<b>Application Ref:</b>	3/2021/0177	 Ribble Valley Borough Council <a href="http://www.ribblevalley.gov.uk">www.ribblevalley.gov.uk</a>
<b>Date Inspected:</b>	N/A	
<b>Officer:</b>	BT	
<b>DELEGATED ITEM FILE REPORT:</b>	<b>NON MATERIAL AMENDMENT</b>

<b>Application Description:</b>	Non Material Amendment of Planning Application 3/2020/1055. Proposed change in colour of fascia boards from white to black; change of white UPVC windows and doors to black aluminium; change utility door from white UPVC to colour composite; delete small window in utility room; insert high level window in the family room on the side elevation; change orientation of roof lantern in kitchen/dining room and increase size to 2.4m x 1.2m.
<b>Site Address/Location:</b>	Mayfield, Whalley Road, Simonstone. BB12 7HT

PROPOSED FLOOR PLANS, ELEVATIONS, SECTION & ROOF PLAN

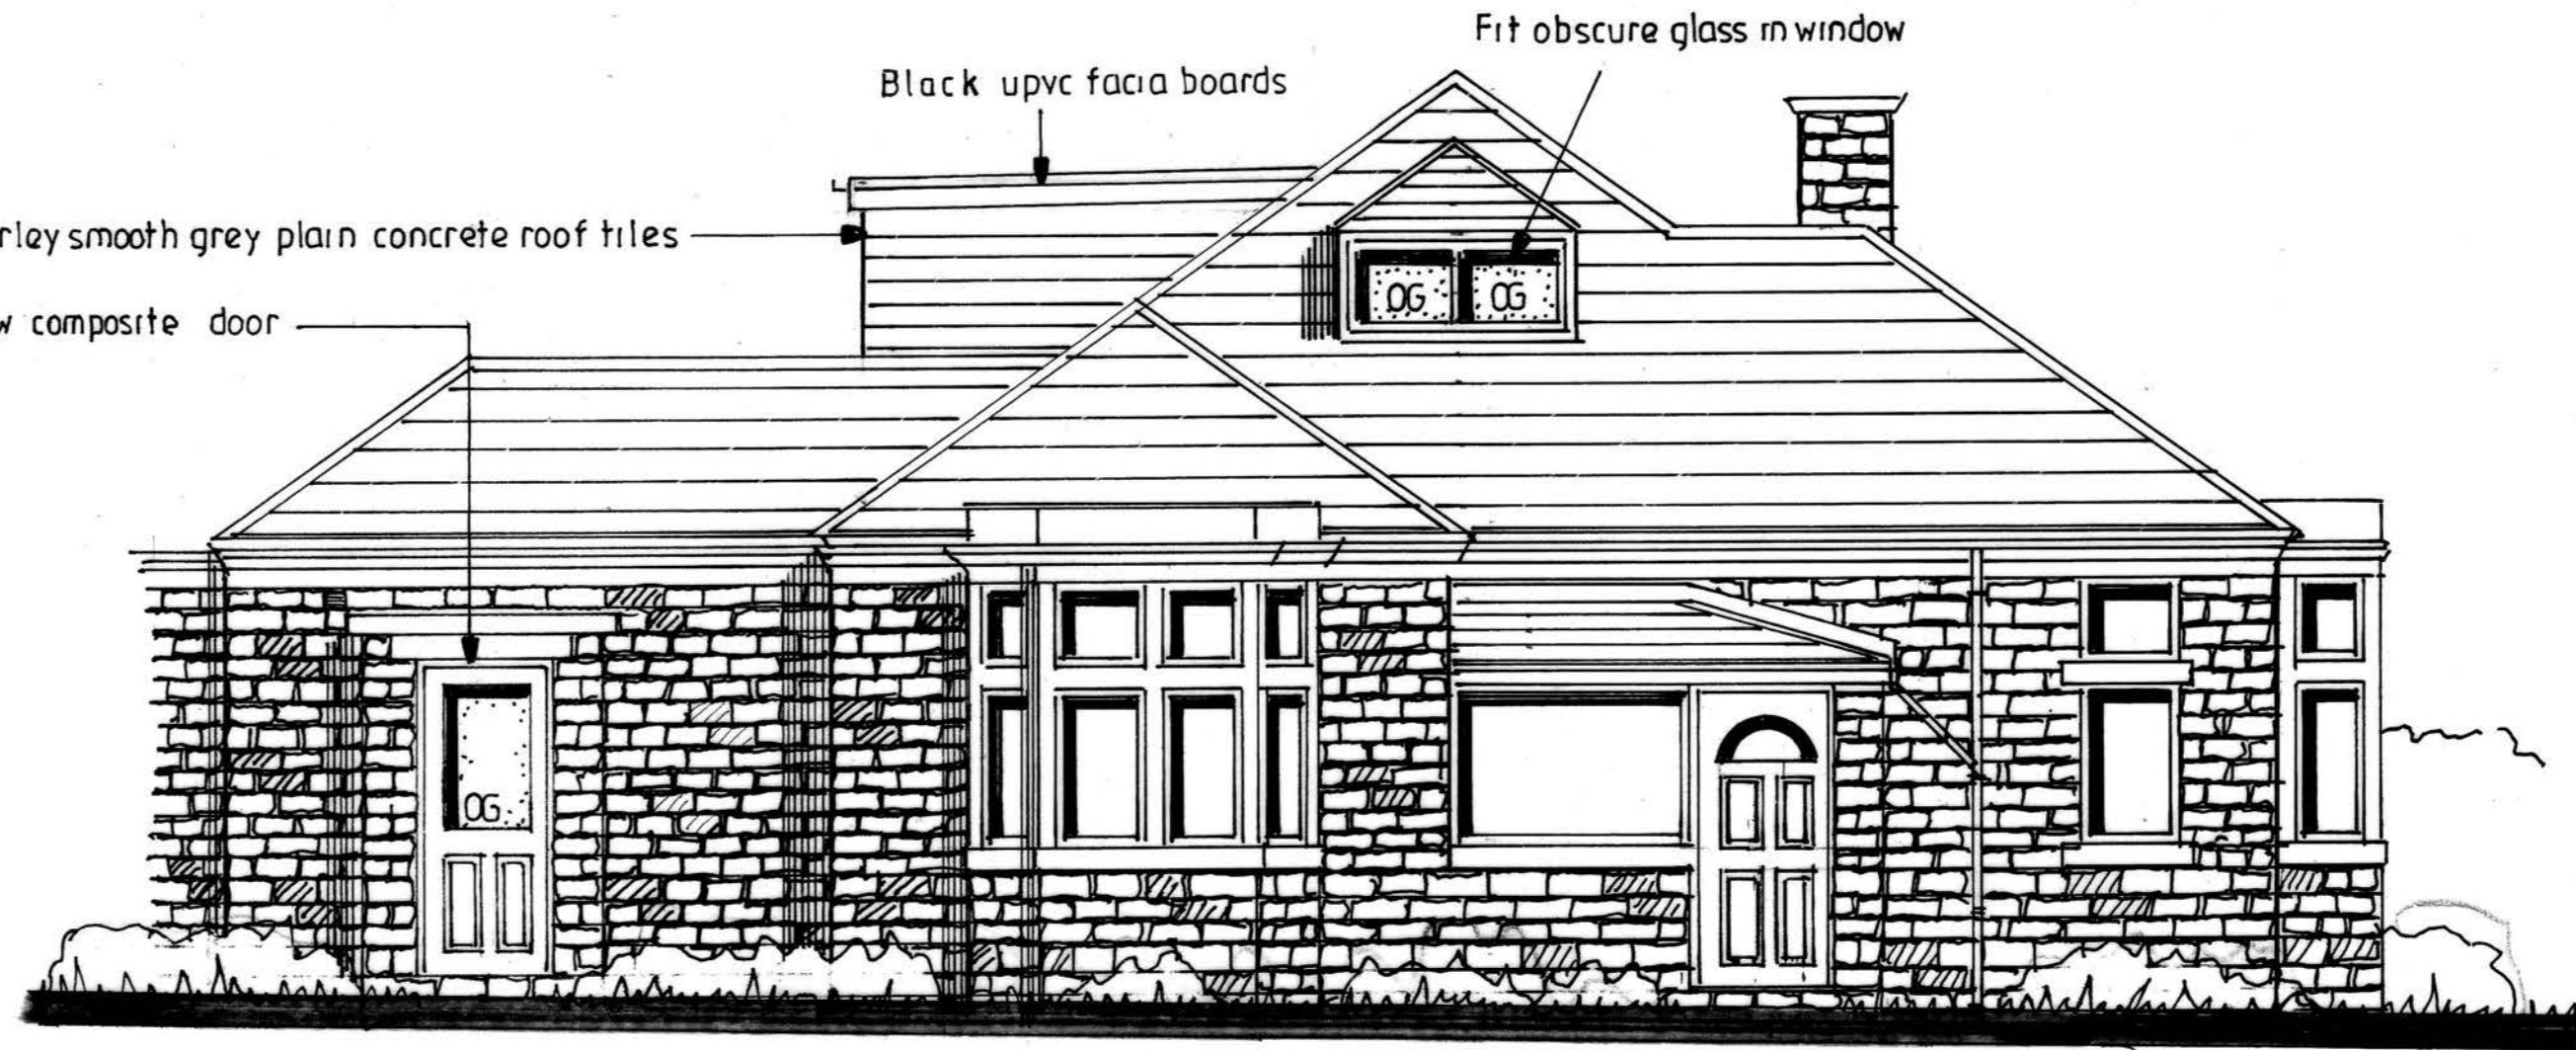
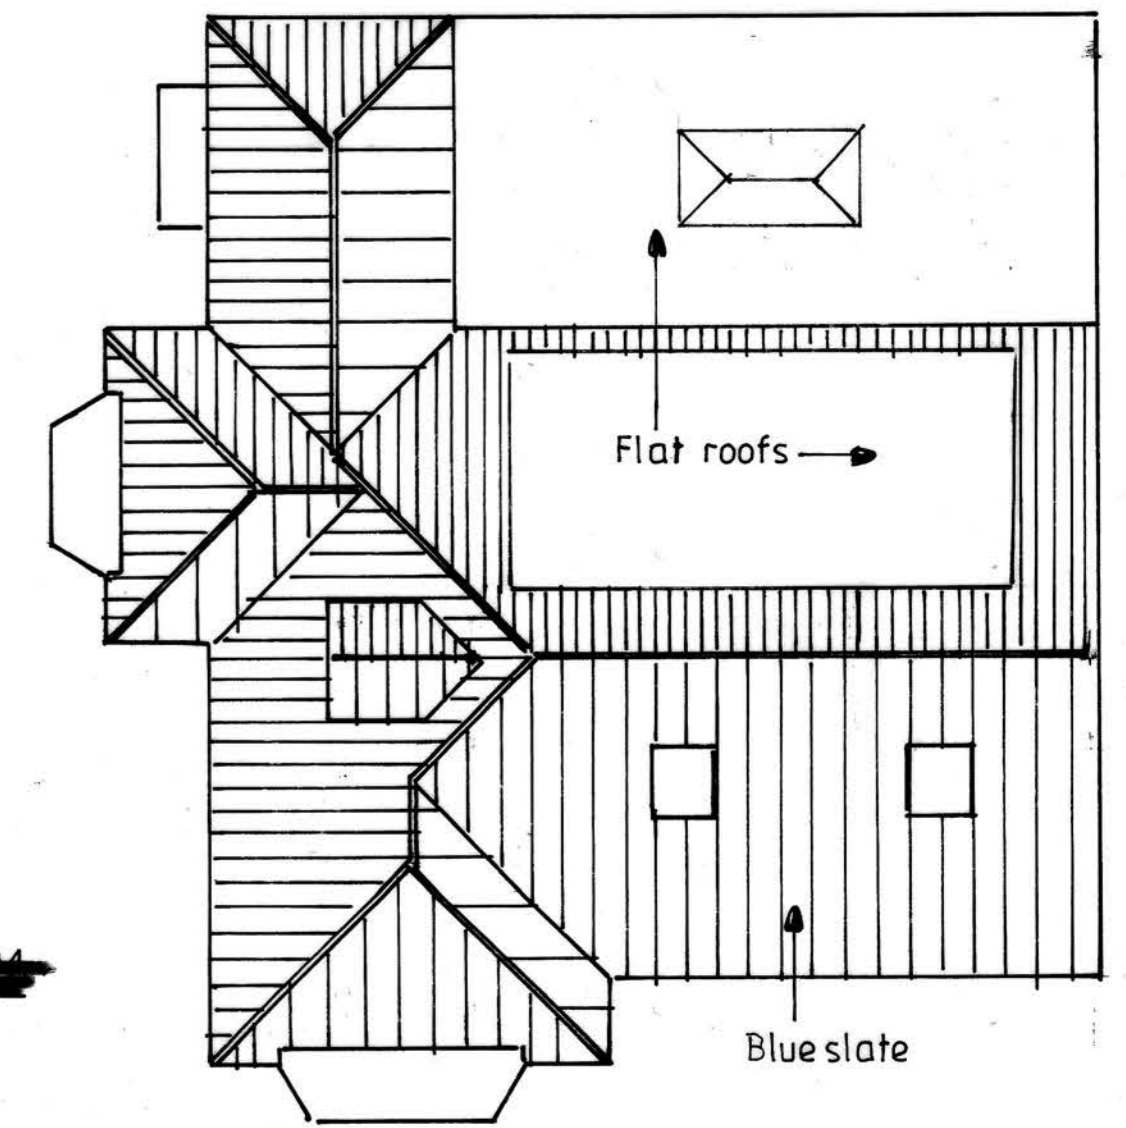
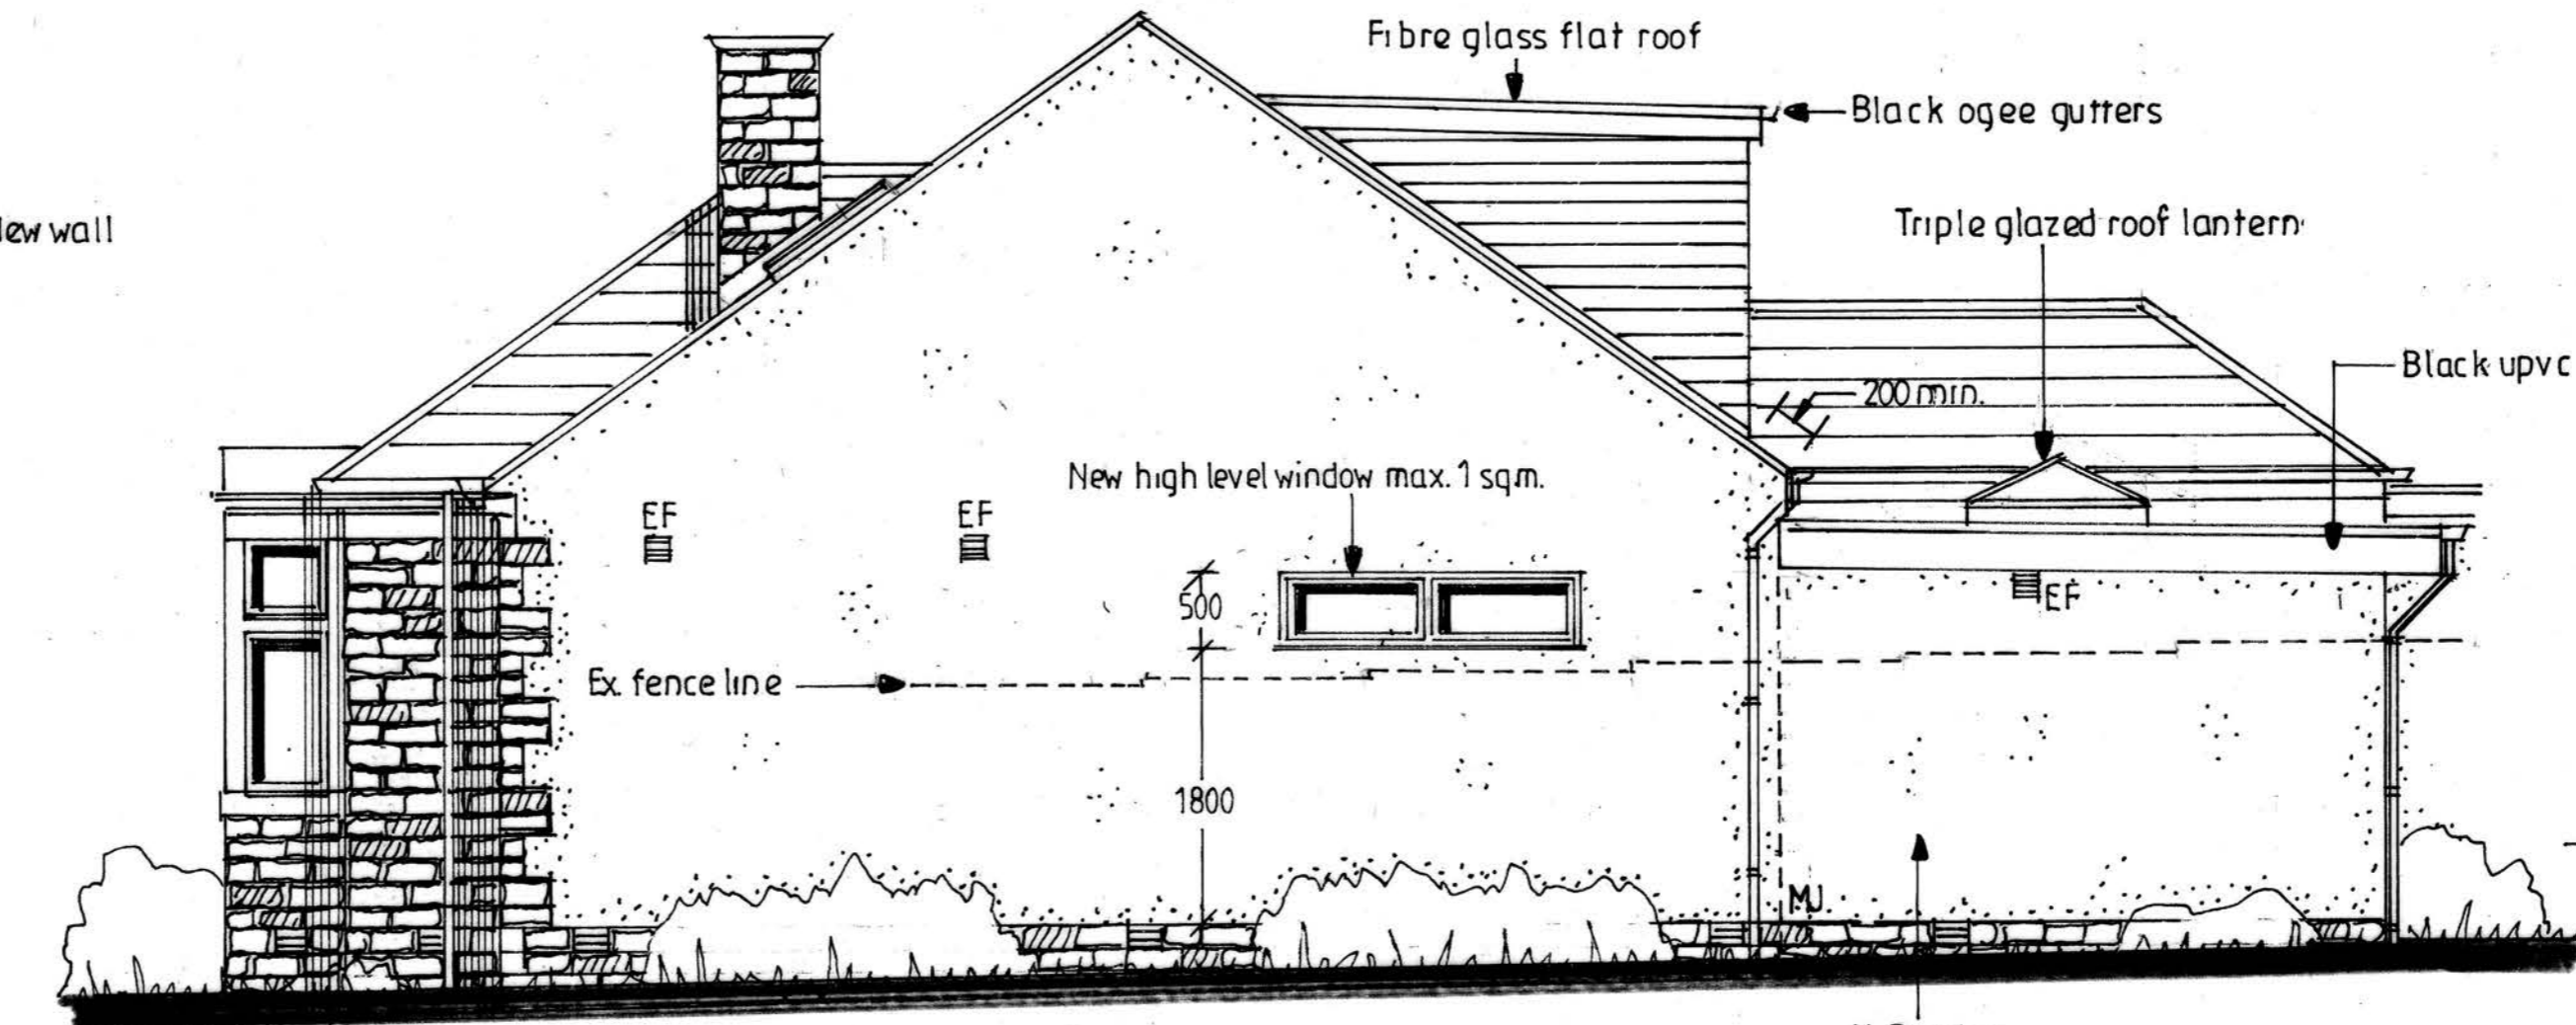
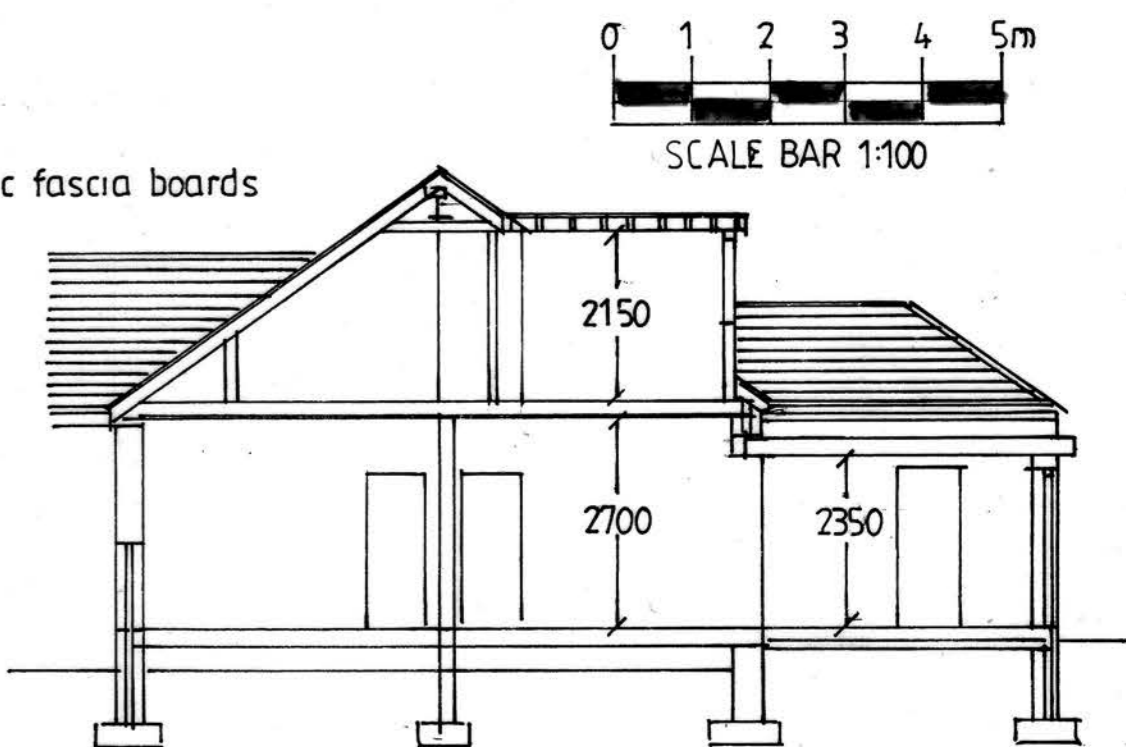
- Removal of small window in utility room
- Insertion of high level window in the family room on the side elevation
- Change orientation of roof lantern in kitchen / dining room and increase size to 2.4m x 1.2m

The applicant has stated that the existing white UPVC windows and doors that were to be retained as part of the approved proposal were found to be in poor condition and in need of replacement hence the applicant wishes to change these to a black aluminium style. The applicant also wishes to change the colour of the proposed fascia boards from white to black in order to integrate with the new UPVC windows and doors.

The applicant has stated that the small window in the utility room is being deleted to allow for additional high level storage units. The applicant also wishes to make minor changes to the orientation and size of the proposed roof lantern in order to provide more light into the property's kitchen.

The application also includes plans to insert a high level window on the South-eastern elevation of the property's in order to provide supplementary light and ventilation into the property's family room. The proposed window would be sited 2 metres above ground level and would cover a maximum surface area of 1 square metre.

The window would be situated above head height and would face towards the gable end of the neighbouring property which does not contain any windows which form part of habitable rooms. As such, it is not considered that the high level window would have any significant impact upon the residential amenity of the neighbouring residents with regards to loss of privacy through overlooking. Moreover, the proposed window would fall within the realm of permitted development by virtue of its positioning on the original house.

The non-material amendment should be granted.

Approve non-material amendment.
